AQUIND INTERCONNECTOR
DCO Parameters Index Document

Document Ref: 7.7.5

PINS Ref.: EN020022

DATE: 6 OCTOBER 2020

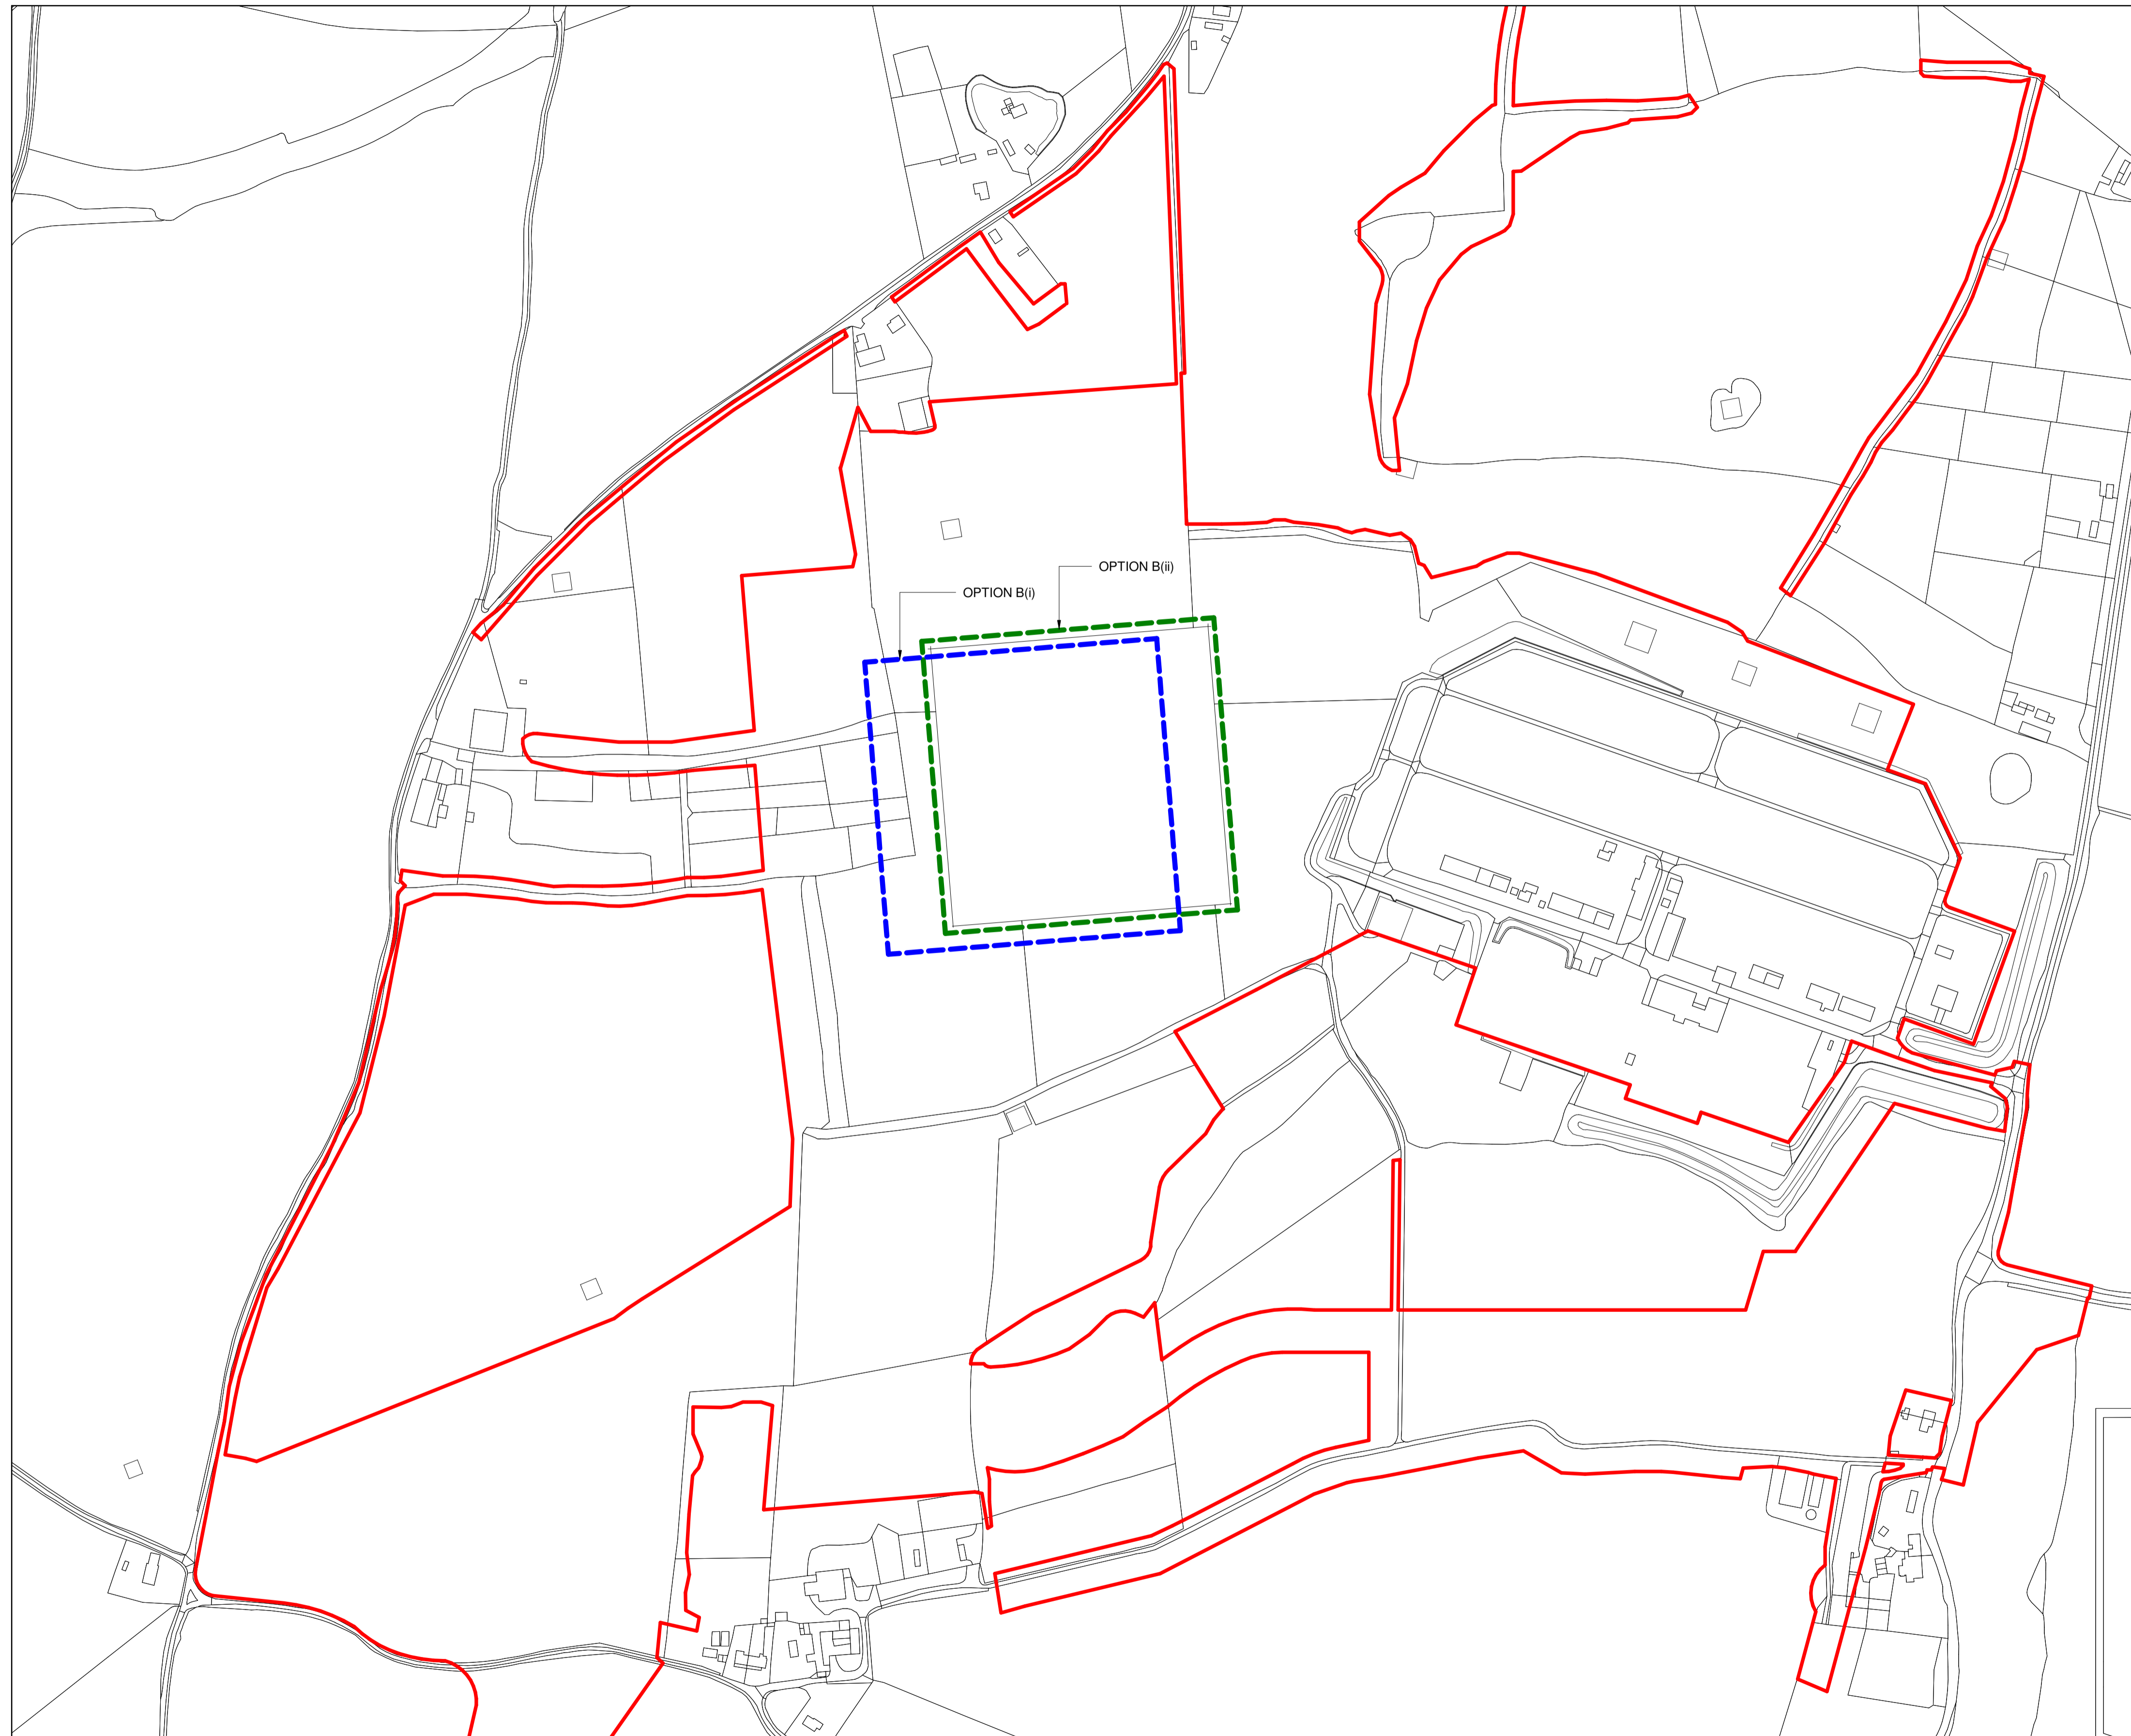
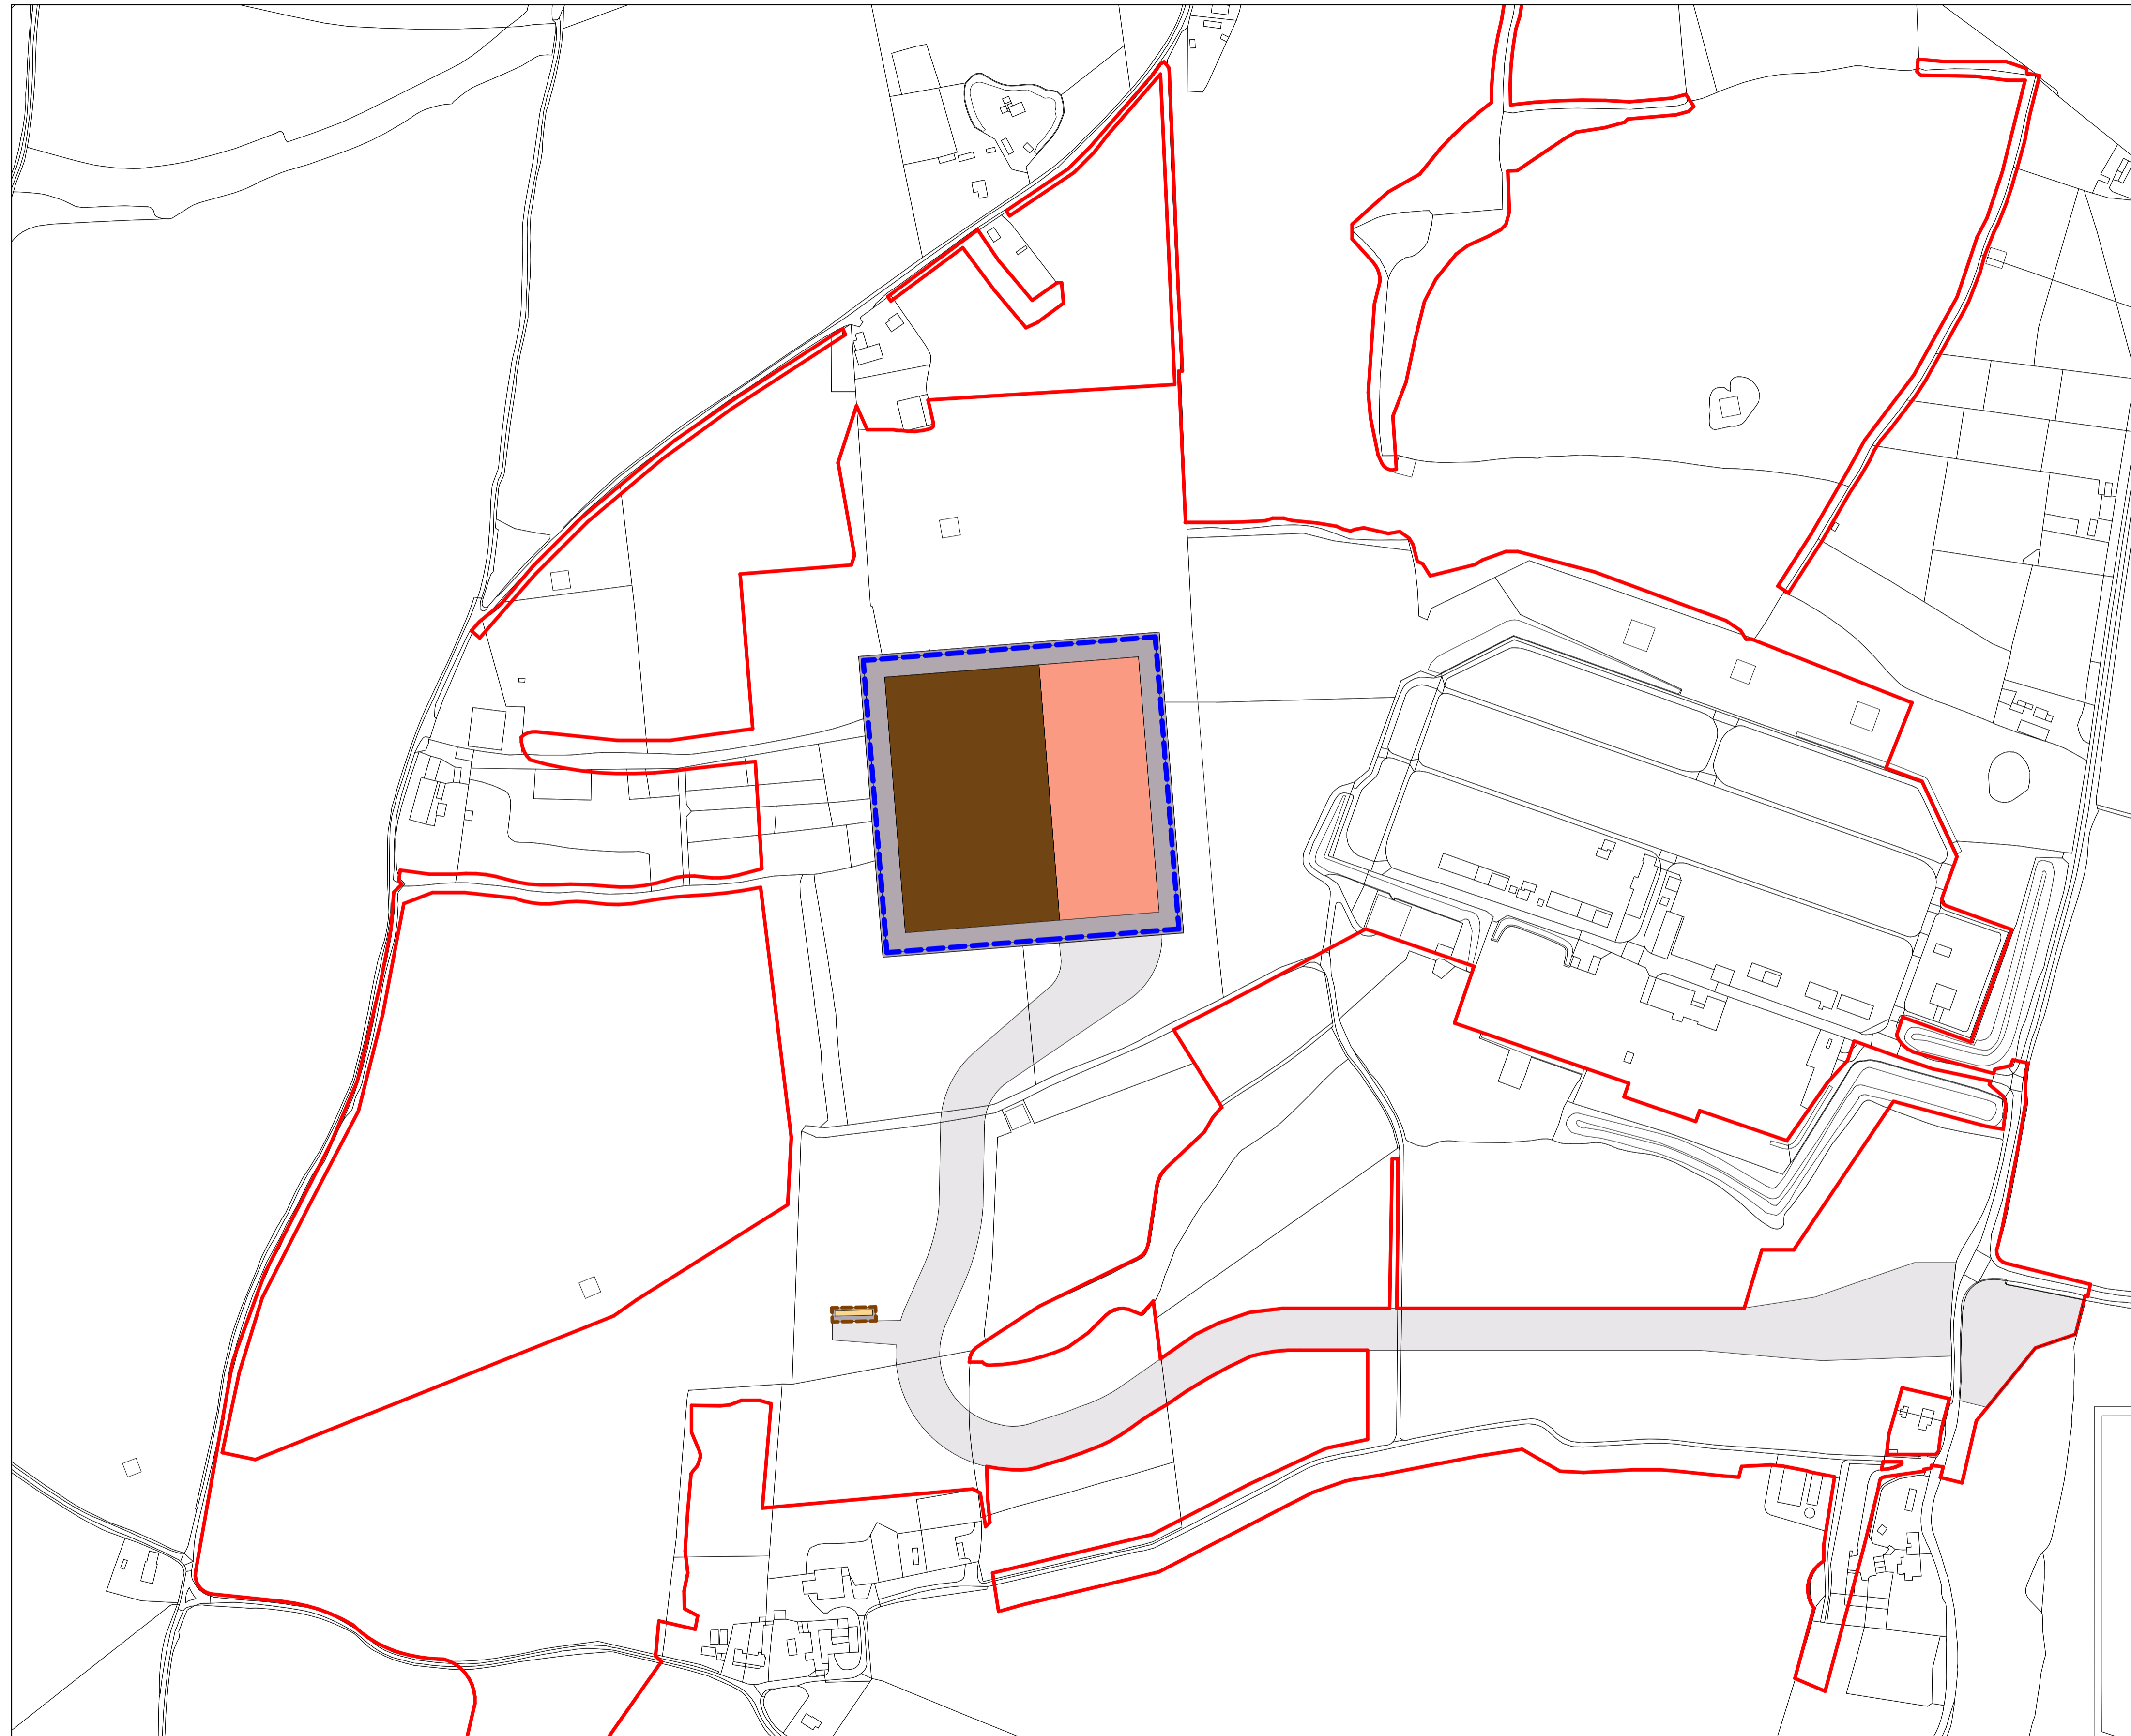
Paragraph 3.6.3.2	The proposed Converter Station area footprint is 200 m x 200 m (4 ha).	Requirement 5 to the dDCO requires compliance with Converter Station and Telecommunications Buildings Parameter Plans. The Converter Station and	No resolution required as position aligned.

Document Location	Parameter stated in ES	Parameter stated within Draft DCO	Resolution
		Telecommunications Buildings Parameter Plans identify a 200m x 200m footprint within which the Converter Station and associated equipment are to be located.	
Paragraph 3.6.3.7	<p>This conversion equipment is housed indoors, within the two Converter Buildings.</p> <p>Each Converter Building will comprise of a steel structural frame and will measure approximately 90 m in length, 50 m in width and up to a maximum of 26 m in height to be measured from finished ground floor slab level.</p>	<p>Work No. 2 in Schedule 1 to dDCO states 2 converter hall buildings.</p> <p>Table WN2 within the dDCO secures the maximum parameters for the Converter Halls as 90m x 50m x 26m.</p> <p>The maximum AOD height of the Converter Hall Buildings is also now restricted by an addition to the Converter Station and Telecommunications Buildings Parameter Plans, which provides the converter halls may not be above 111.10m AOD in height.</p>	No resolution required as position aligned, though clarification included on The Converter Station and Telecommunications Buildings Parameter Plans in relation to maximum AOD height.

Paragraph 3.6.3.9	The Control Building (item 2 in Plate 3.7) ... will comprise a two-storey building with steel frame structure ... with a maximum overall height of 15 m, to be measured from finished ground floor slab level.	Table WN2 at Requirement 5 to the dDCO does not state control building maximum parameters.	Draft DCO updated to confirm maximum parameters of Control Building as 26m in length x 50m in width x 15m in height.
Paragraph 3.6.3.11	The spare parts building (item 9 in Plate 3.7) will comprise a maximum 15 m high single storey steel frame structure ... and a 2.4 m high internal perimeter for robustness.	No parameters stated in dDCO.	Draft DCO updated to confirm maximum parameters for the spares building of 27m in length x 25m in width x 15m in height and reference an internal perimeter fence for the spares building with a maximum height of 2.4m.
Paragraph 3.6.3.12	The lightning masts can generally be up to 4 m taller than the tallest building, are tall, narrow structures, with catenary wiring strung between them to shield the outdoor equipment from direct lightning strikes.	<p>Maximum height of lightning masts stated to be 30m in Table WN2 at Requirement 5 to dDCO.</p> <p>The position is also confirmed on the Converter Station and Telecommunications Buildings Parameter Plans, which Requirement 5 requires compliance with.</p>	No resolution required as position aligned.

Paragraph 3.6.3.43	To keep the excavation within structureless chalk strata to mitigate contamination of the aquifer, 84.80m AOD has been proposed as Converter Station general finished level. Following initial Flood Risk assessment, the Converter Building finished floor level has been proposed to be 85.10m AOD (300mm above finished site level). Therefore, for the basis of the EIA assessment, 85.10m AOD has been used.	The Converter Station and Telecommunications Buildings Parameter Plans confirm heights indicated are heights above finished ground floor slab level of +85.100 AOD. Whilst this level is indicative, it confirms the assessment is aligned with the parameters regarding heights of buildings which this ground floor level is relevant to.	No resolution required as position aligned.
Paragraph 3.6.4.1	The Onshore Cable Corridor represents the maximum extent of the area within which the Onshore Cables may be located, otherwise described as the limits of deviation.	The Onshore Cable Corridor aligns with the extent of the limits of deviation shown for Work No. 4 on the Works Plans (APP-010).	No resolution required as position aligned.
